CITY OF ALBUQUERQUE  
PLANNING DEPARTMENT  
DEVELOPMENT REVIEW BOARD

**Project# 1009046**

12DRB-70115 MAJOR - PRELIMINARY PLAT APPROVAL

MARK GOODWIN AND ASSOCIATES, P.A. agent(s) for SAWMILL CROSSINGS, LLC request(s) the referenced/ above action(s) for Tract B1A2, **DUKE CITY LUMBER CO ADDITION**, zoned SU-2/S-I (proposed SU-2/ SU-1 PRD), located on the south side of ASPEN AVE NW between 12<sup>TH</sup> ST NW and 19<sup>TH</sup> ST NW containing approximately 6.9292 acre(s). (H-13)[*Deferred from 5/2/12, 5/23/12, 6/6/12*]

SAWMILL CROSSING
SITE PLAN FOR SUBDIVISION

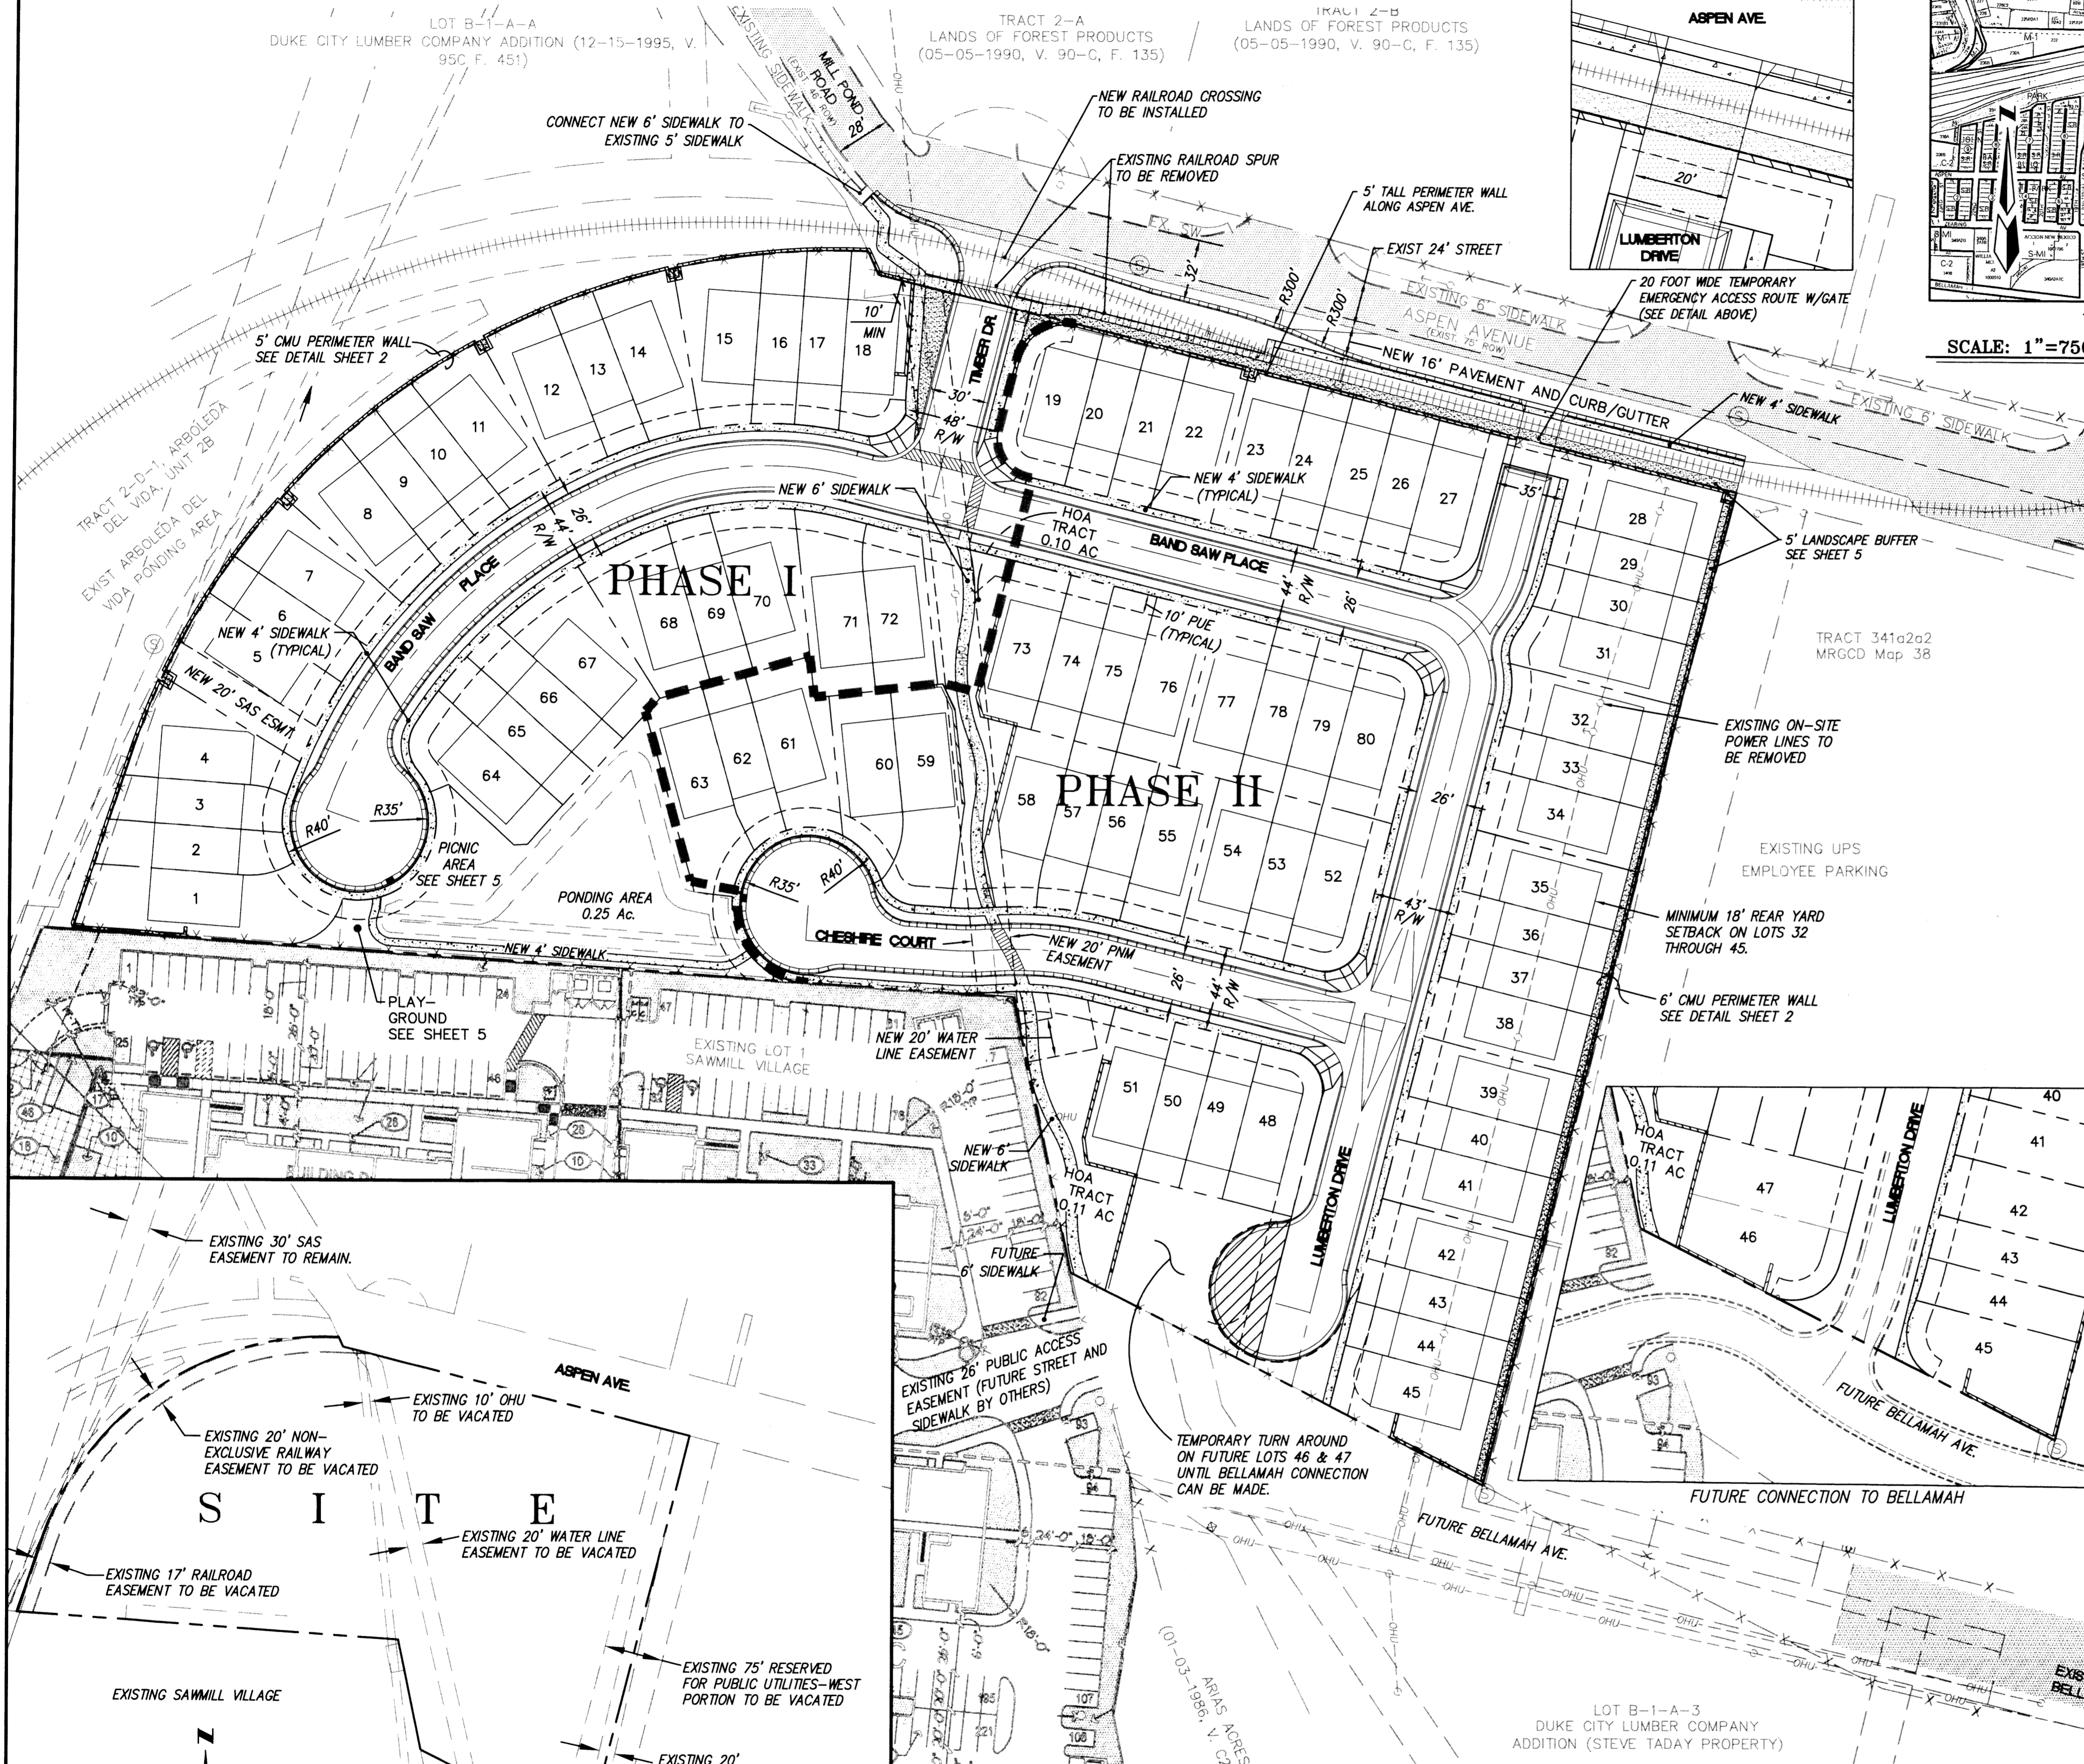
hearing.” The additional conditions were as follows: 1) Mr. Mackenzie agreed to expand the easement around the transmission pole in the northern portion of the development for truck access. 2) Proposed playground equipment will be moved farther away from transmission line (at least 40’ away). 3) The proposed landscaping will be changed to use tree species, which will be shorter at maturity around transmission line easement (15’ max height). 4) The existing easement will be expanded from 10 to 20 feet in width. 5) Vertical clearance – 13’ for roofs not accessible to pedestrians. Any structure that does not meet horizontal clearance, must meet vertical. 6) PNM will continue to work with developers to safely develop property in relation to its transmission system.

Displayed on the Site Plan for Subdivision just west of the site's entry off Aspen Ave. was a proposed vacation of approximately 209 SF of R/W at the time of EPC's approval. This is where Aspen Ave. transitions east to west from 75 feet of right-of-way to 46 feet of right-of-way for Mill Pond Road. At that time it was believed this area could be considered excess public R/W that could be more advantageous for the applicant to own instead of the City. The vacated area was to be absorbed into the development and then bounded by a site perimeter wall. See attached Exhibit A-1. The dead-end rail spur shown on top of this property is to be removed during site development.

Design of the site's infrastructure was started earlier this month, not long after a more detailed topographic survey of the site was obtained. At that time it was discovered that an existing 12" cast iron water line ran beneath the area of the R/W proposed vacation. If this small area of R/W were to be vacated and then purchased from the City by the applicant, he would have to immediately turn around and grant a new 20-foot wide waterline easement to the Utility Authority on top of it. The Authority typically does not allow CMU privacy walls to be constructed on their easements, so the area would have to remain outside of the site's perimeter wall, thus rendering the advantage of a vacation relatively worthless. See attached Exhibit A-2 identifying the water line and its mandatory easement, which would have to be located 10 feet on each side of the existing line.

As a result I request that there be no mandate for this vacation to be pursued and the Site Plan for Subdivision be allowed to not display the 209SF of Aspen Ave. vacation as originally proposed, so it can be approved by the DRB in accordance with the attached Exhibit A-3. If you concur with this minor site plan modification, please initial in the following space so it can then be forwarded to the DRB Chair prior to final sign-off.           *CM Marrone*

The applicant has met all of PNM’s additional conditions. The changes are shown on the site plan for subdivision and under notes on the landscape plan.
